**From:**  
**Sent:** 15 September 2023 12:35  
**To:** DCAdmin  
**Subject:** 2023/92255 - 2023/92327 - 2023/92254 - 2023/92253

2023/92255 Land at Green Acres Close, Emley, Variation of Conditions 1 (Plans) , 2 (Crime Prevention) and 15 (Permitted Development) of Previous reserved matters approval 2021/93286 pursuant to outline permission 2020/91215

2023/92327 Land at Green Acres Close – modified plans for 6 Dwellings plus parking and landscaping and modified plans for ball stop netting.

2023/92253 Land at Green Acres Close – Discharge of conditions 6 (Highways) 7 (PROW) 10 (CEMP) 11 (Drainage) 27 (Ball Stop Netting)

Construction Management Plan (drawing reference NLM-005-A)

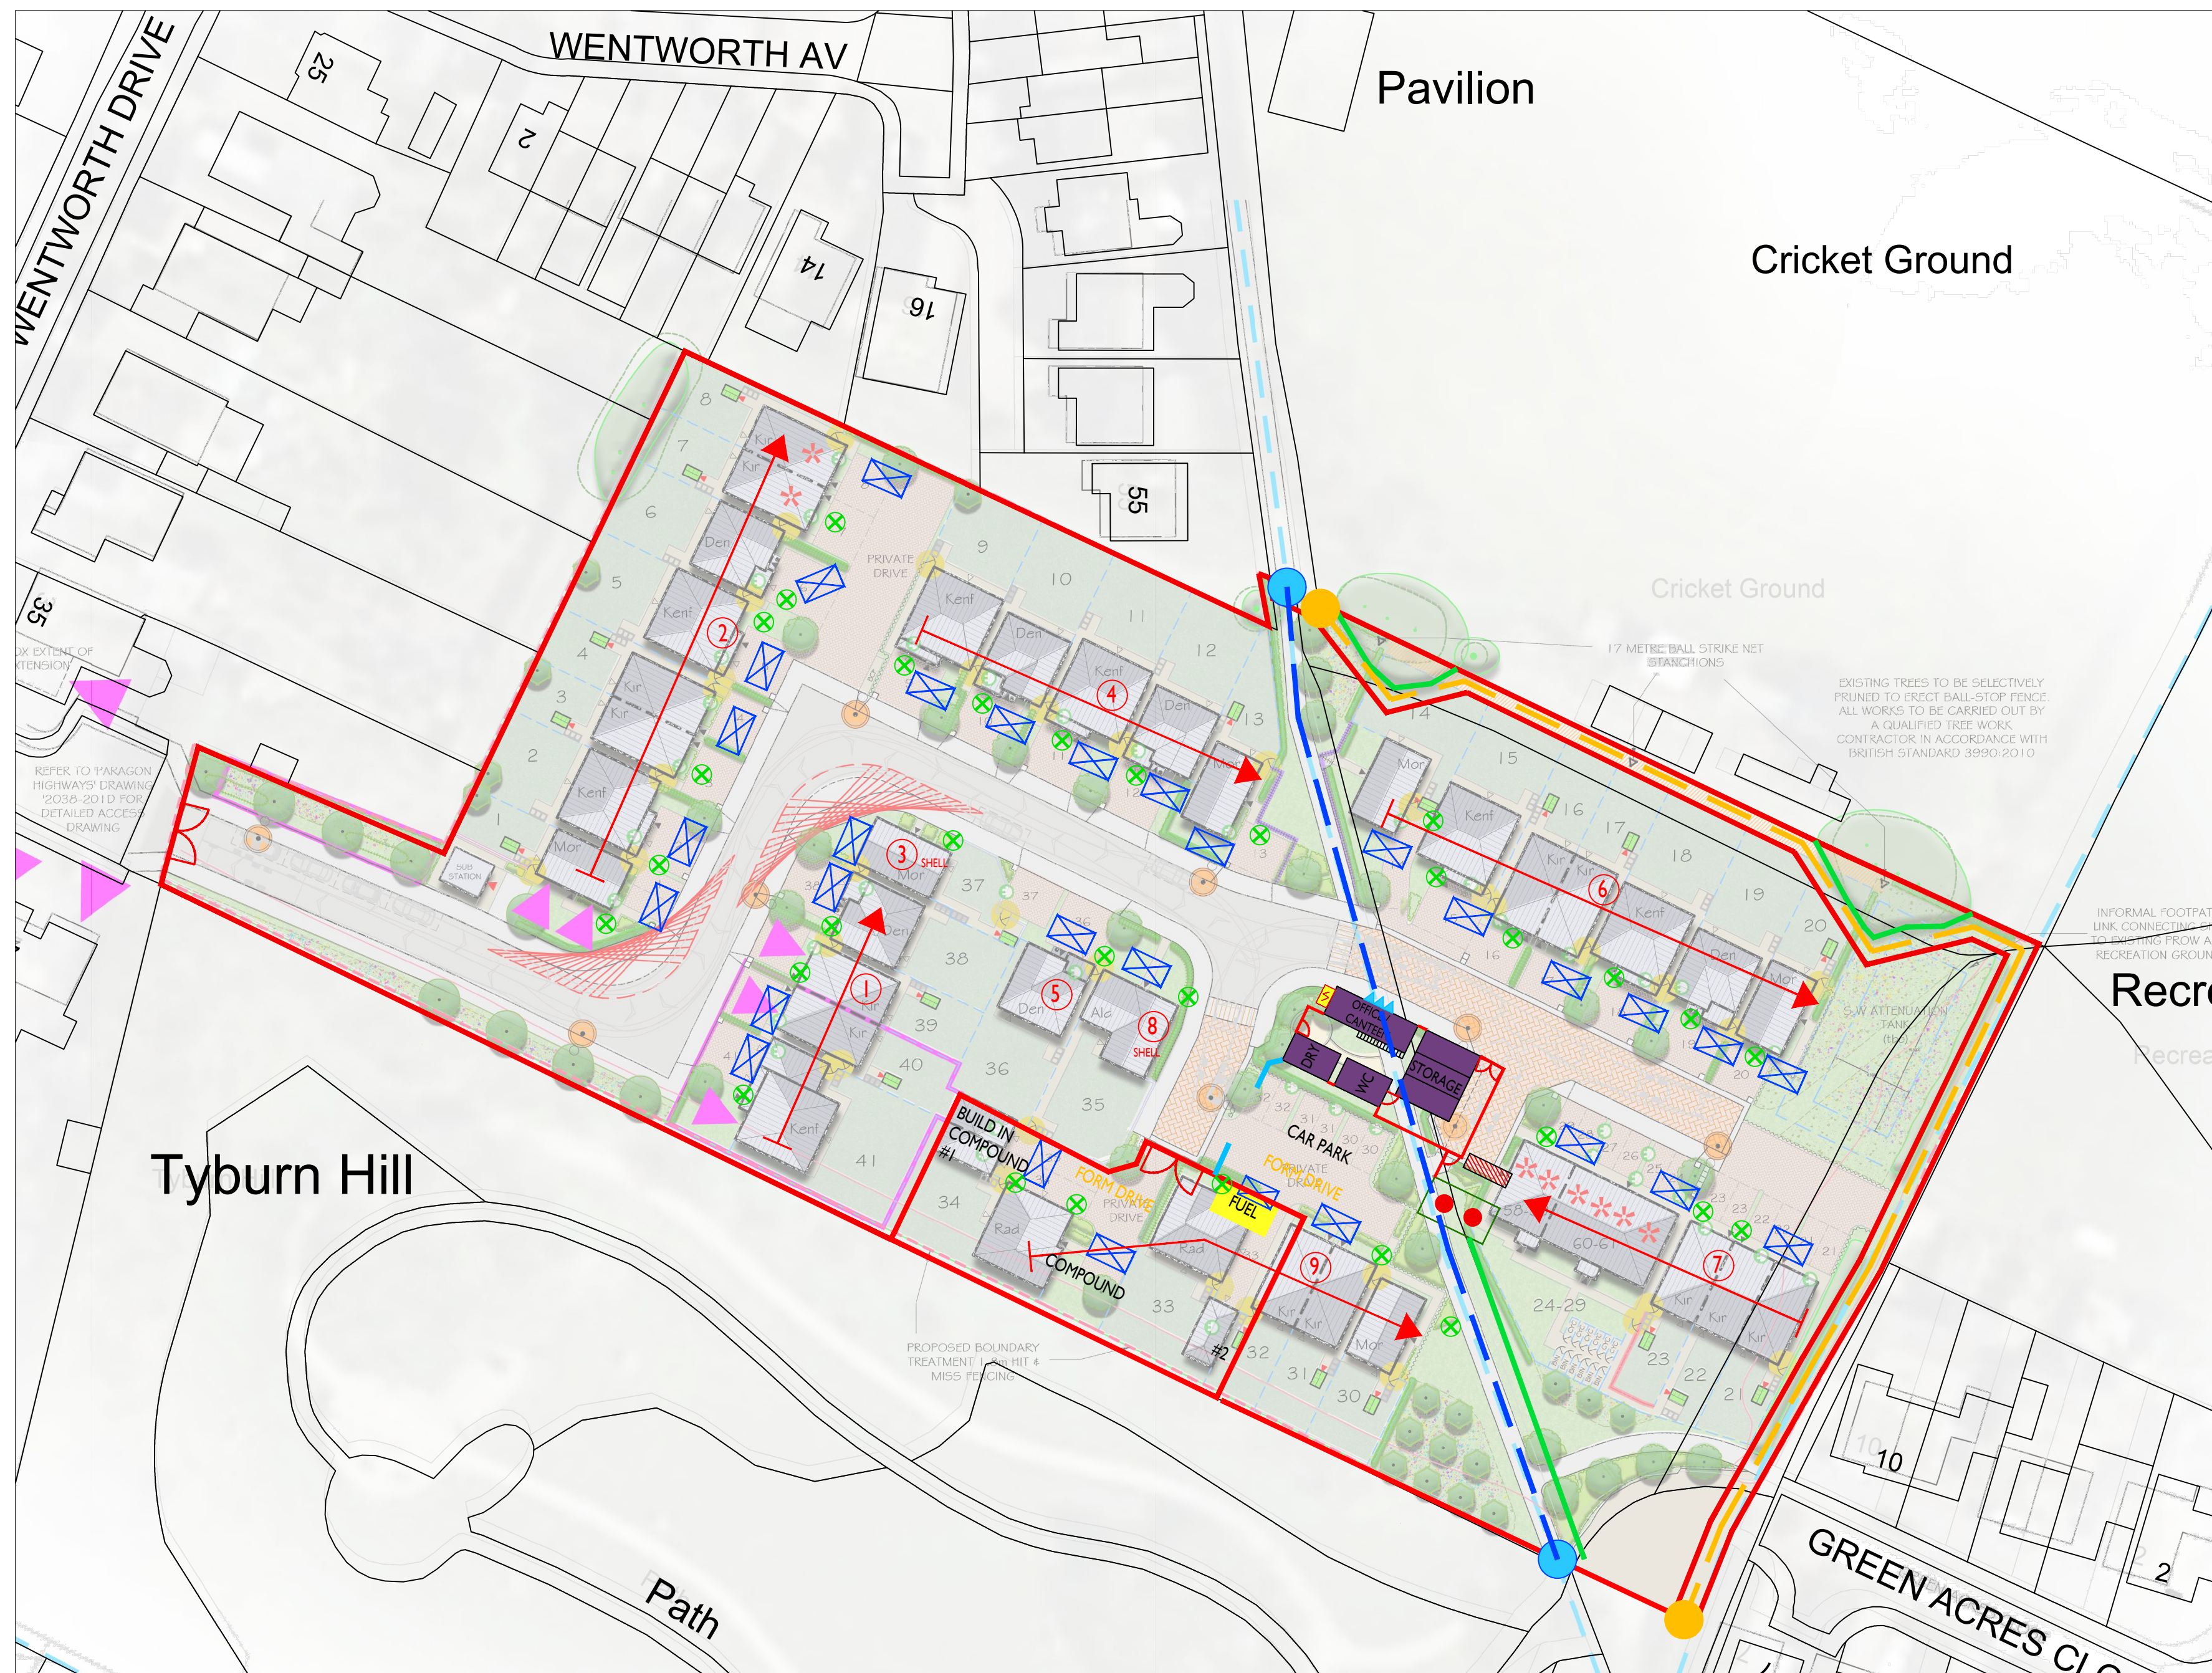
1 - How do Newett Homes propose to protect the Millennium Green's trees, bushes and wildlife during the development from construction debris, dust and mud, from excess construction noise and artificial lighting. The Millennium Green is used for the release of recovering hedgehogs from the nearby hedgehog hospital. Newett Homes is aware of this and has been approached by the hedgehog hospital with a request to enter the development site to monitor and/or re-

home such hedgehogs who may be along the boundary and within the development site. Newett Homes needs to factor this into any of their construction management plans. There also needs to be suitable protection of tree roots on the boundary of the Millennium Green throughout the development phase.

2 – How will Newett Homes ensure access to the Emley Millennium Green and other public areas are not impeded during the development.

6 – Parking of construction workers vehicles will be an issue, what are the plans?

7 – Reassurance that the access from Green Acres Close will not be used by construction workers or deliveries.
